KIRKLEES METROPOLITAN COUNCIL INVESTMENT & REGENERATION SERVICE

DELEGATED DECISION TO DETERMINE PLANNING APPLICATIONS

Reference No:	2025/62/91800/W
Site Address:	34, Woodlea Avenue, Marsh, Huddersfield, HD3 4EF
Description:	Erection of first floor side extension
Recommending Officer:	Molly Storer

Officer Report

Front Elevation (North Facing)
1 : 100

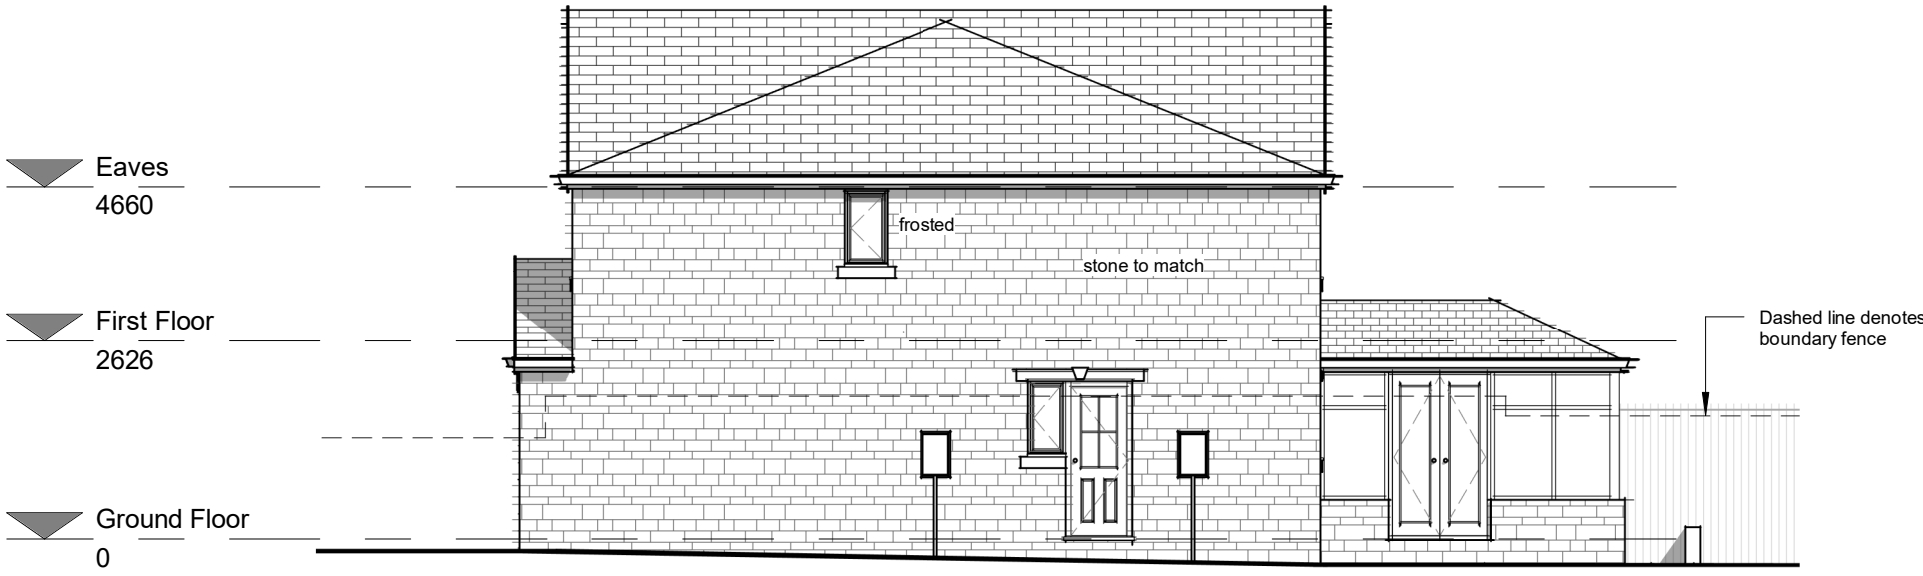
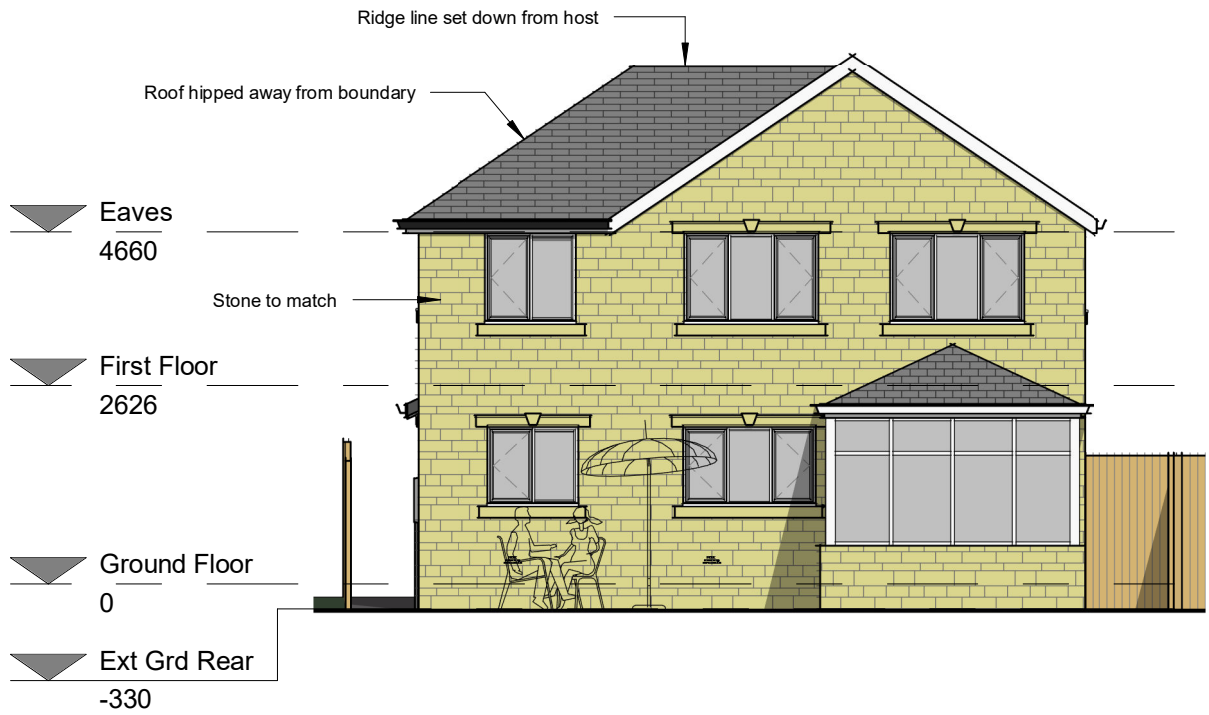
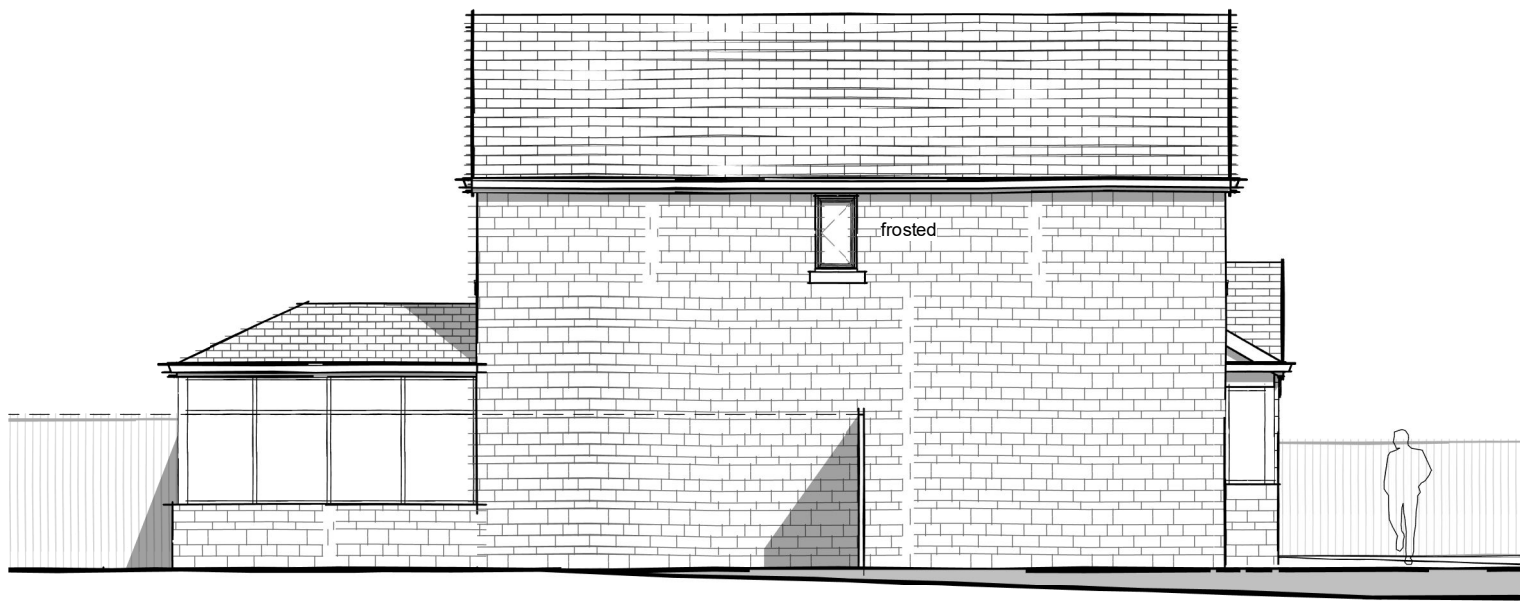
It is proposed that the eaves height would match the existing at 5m and would slightly be set down from the existing roof ridge by 0.15m with an overall height of 7.1m with a hipped roof form. Construction materials would be stone and concrete roof tiles to match the existing.

The agent was contacted as the design of the extension is not SPD compliant. The plans show the front elevation to be flush and the eaves height to be the same. To comply fully with the SPD the front elevation of the extension should set back from the front elevation of the house by at least 500mm and the roof line should be set down from the existing roof. It was suggested that as the extension did not 'comply' with the SPD, further justification of the proposal would be required. The agent provided justification which was deemed acceptable by officers. This will be discussed further within the following report.

In this case the proposed extension would fail to meet the above criteria in terms of not being set back from the front elevation and not having a roof line set down from the roof ridge. However, as there is no change to the footprint of the dwelling, a gap of 1 metre between the side of the extension and the boundary with No. 32 would be retained. As there is no increase in footprint, the outdoor areas of the property would not be compromised or lost as a result of the works.

As required by the SPD paragraph 1.11, should a development depart from the guidance set out justification is required. The agent has provided justification by highlighting the hipped roof design was incorporated to reduce the overall bulk of the side extension. Furthermore, although at first floor level the extension would be flush with the front elevation, the existing ground floor already protrudes out from the first floor's front elevation, resulting in a stepped-back appearance to the front of the property. Furthermore, the ridge is set down by 0.35m, this creates an appropriate design, creating a visual break from the original roof ridge.

Paragraph 5.21 of the SPD explains that two storey and first floor side extensions can cause a negative impact on the street when used to close the gap between semi-detached and detached dwellings which can create a terracing effect in a non-terraced street. In this case, due to the design of the host property being different to the design of the closest neighbour at No. 32, it is considered that a terracing effect would be avoided in this case. Furthermore, the use of matching materials to the original dwelling will create a visually sympathetic design.

First Floor
1 : 50

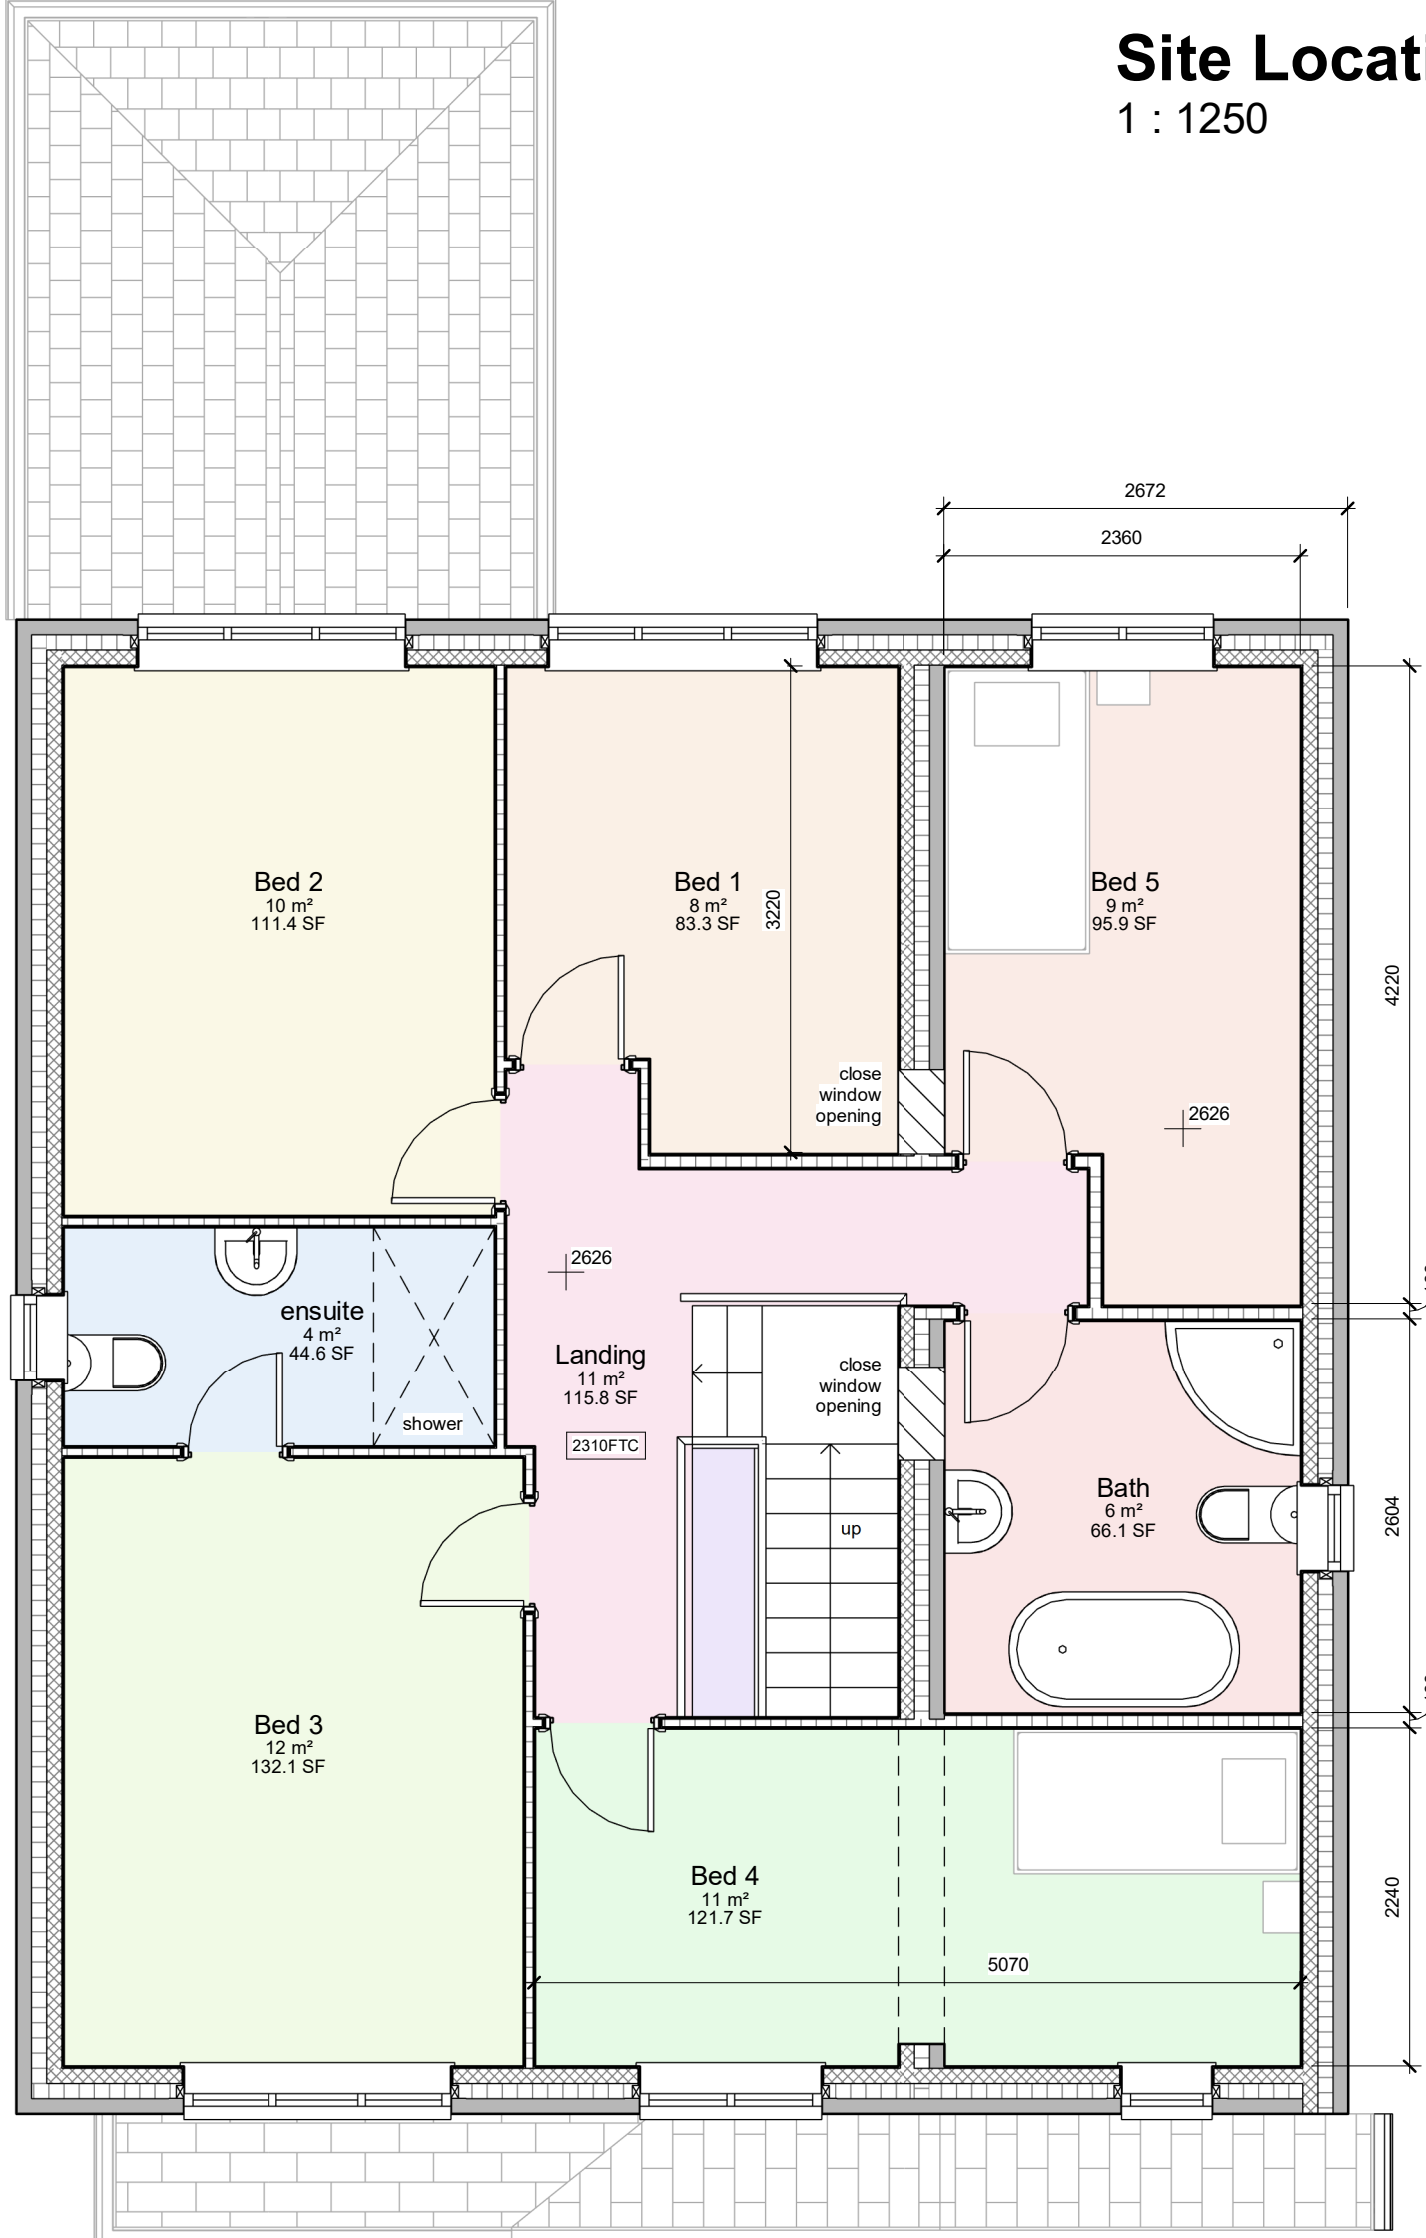
In terms of the impact on privacy, there is one first floor window within the west facing side elevation however plans show this to serve a bathroom and to be obscurely glazed. There are no other openings within the first floor side elevation that would overlook the amenity space of No. 32. There is a new bedroom window proposed to the rear elevation however this is not considered to significantly impact No.32 given that the rear elevation does not align with No.34. This window would only partially look over the neighbouring garden but would primarily face onto the applicants own land and is not considered to cause any further significant harm than other windows within the rear elevation. There are no dwellings directly to the rear of the property that would be affected and therefore the works would have limited impact on privacy from this elevation. There are no dwellings directly to the rear of the property and in terms of the facing properties there would be no reduction in separation distances as a result of the proposed works. It is therefore considered that the proposal would accord with Principles 3 and 4 of the SPD.
